June 30, 2017

**RE: Tract 3, Paradise Plaza
Grading Plan
Stamp Date: 6/23/17
Hydrology File: A11D012A**

Based upon the information provided in your submittal received 6/23/2017, the Grading Plan **is not** approved for Building Permit. The following comments need to be addressed for approval of the above referenced project:

CG-101

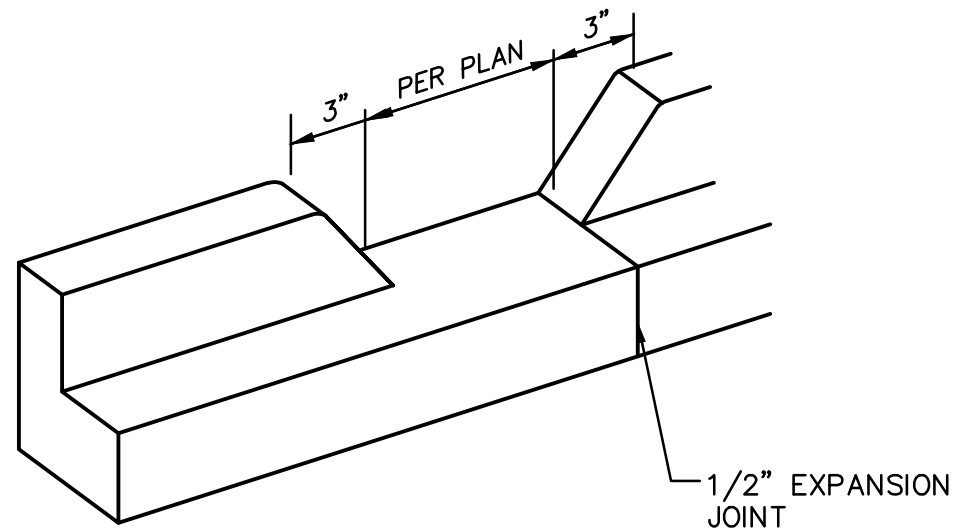
1. On Sheet CG-101. Please provide the water block on the existing drive near the existing retention/detention pond.

2. On Sheet CG-101 under the Drainage Plan Concept. Please state that this tract follows the Drainage Master Plan titled, Supplemental Drainage Information for Paradise Plaza (Tracts 1, 2, & 3) by Isaacson & Arfman dated 8/14/08.

3. On Sheet CG-101 under the First Flush Requirement. It mentions "see supplemental Information Packet". This was not submitted. If this is not going to be, then please remove the note. If this refers to the information noted in the above comment, then just change this note to read, " See Supplemental Drainage Information for Paradise Plaza (Tracts 1, 2, & 3) by Isaacson & Arfman dated 8/14/08".

**CG-501**

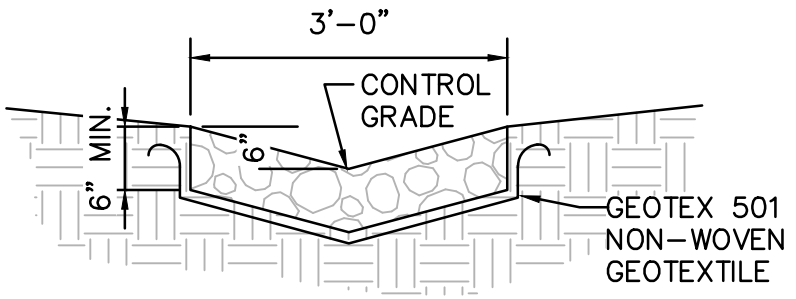
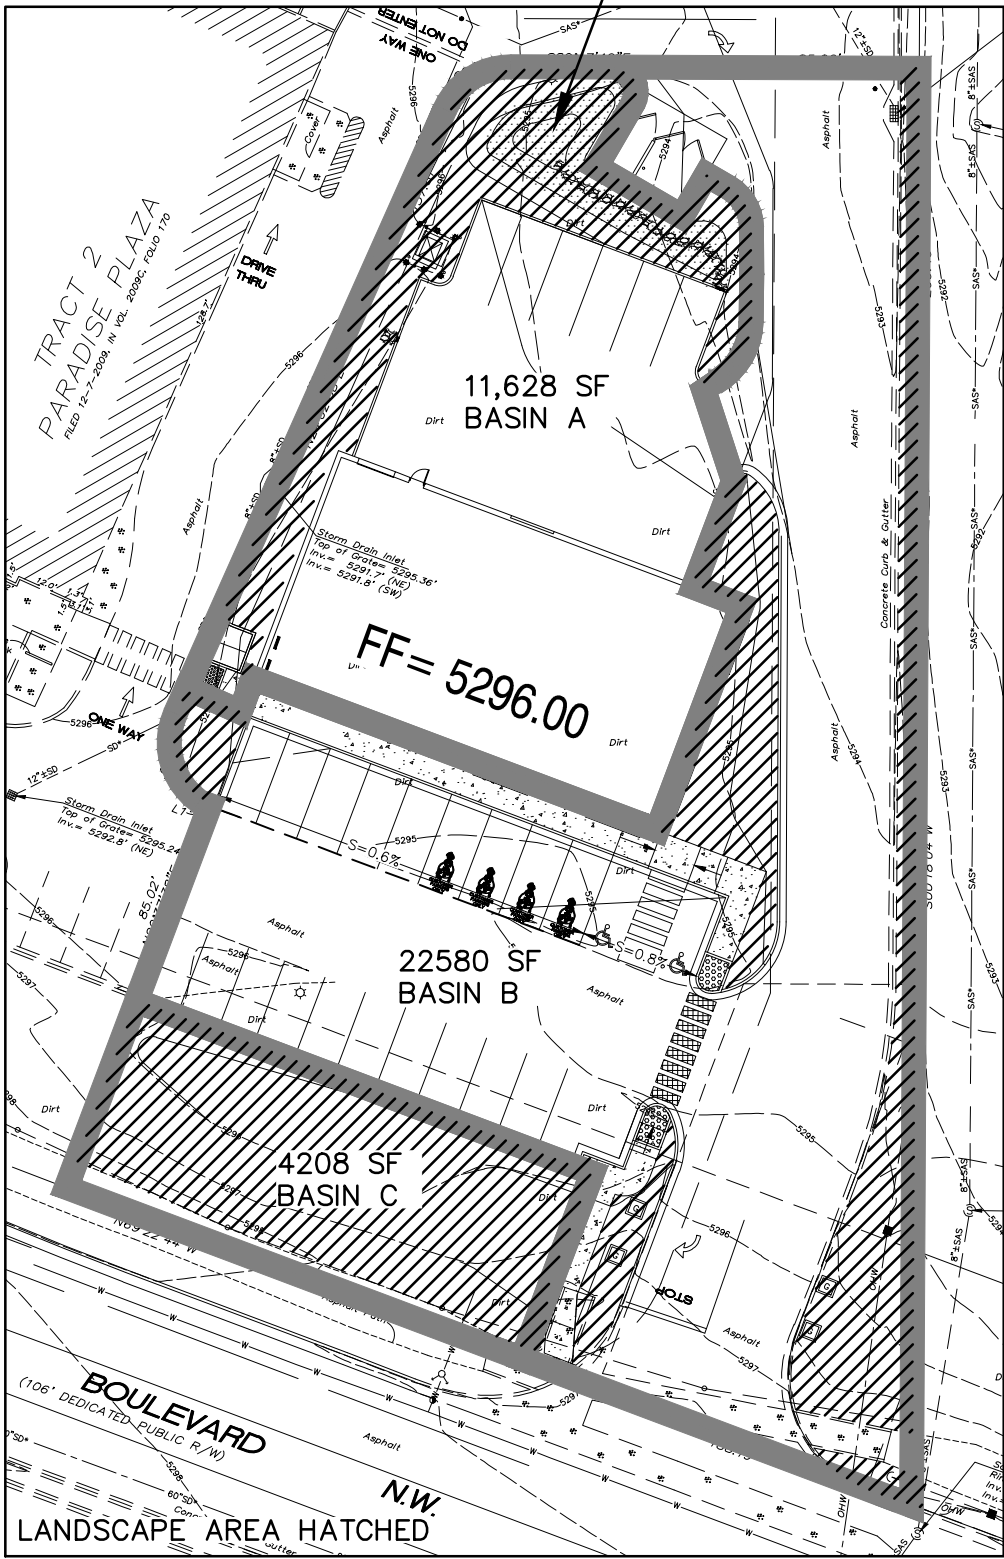
4. On Sheet CG-501. For Tract 3, the calculated Q for the 100 Year - 6 hour is 3.5 cfs. According to the Supplemental Drainage Information for Advance Auto (Tracts 1) by Isaacson & Arfman dated 4/26/16, the existing detention pond has the capacity to only handle 3.2 cfs from Tract 3. Please provide the calculations that will support the additional runoff from Tract 3 in the existing detention pond.

5. On Sheet CG-501. Please provide the weir calculations for both of the curb cuts for the first flush basin.
6. On Sheet CG-501. Please expand the viewport to include the existing retention/detention pond.
7. On Sheet CG-501. Please show the detention volumes provided for Tracts 1, 2, & 3 and then provide the total volume of the pond. This information should be in a table which points to the existing pond.
8. On Sheet CG-501. Please make a note that the first flush volume for Basin B will be handled within the existing retention/detention pond.
9. On Sheet CG-50 on the Rock Erosion Protection Detail. Please provide the Rock type and size in the detail.
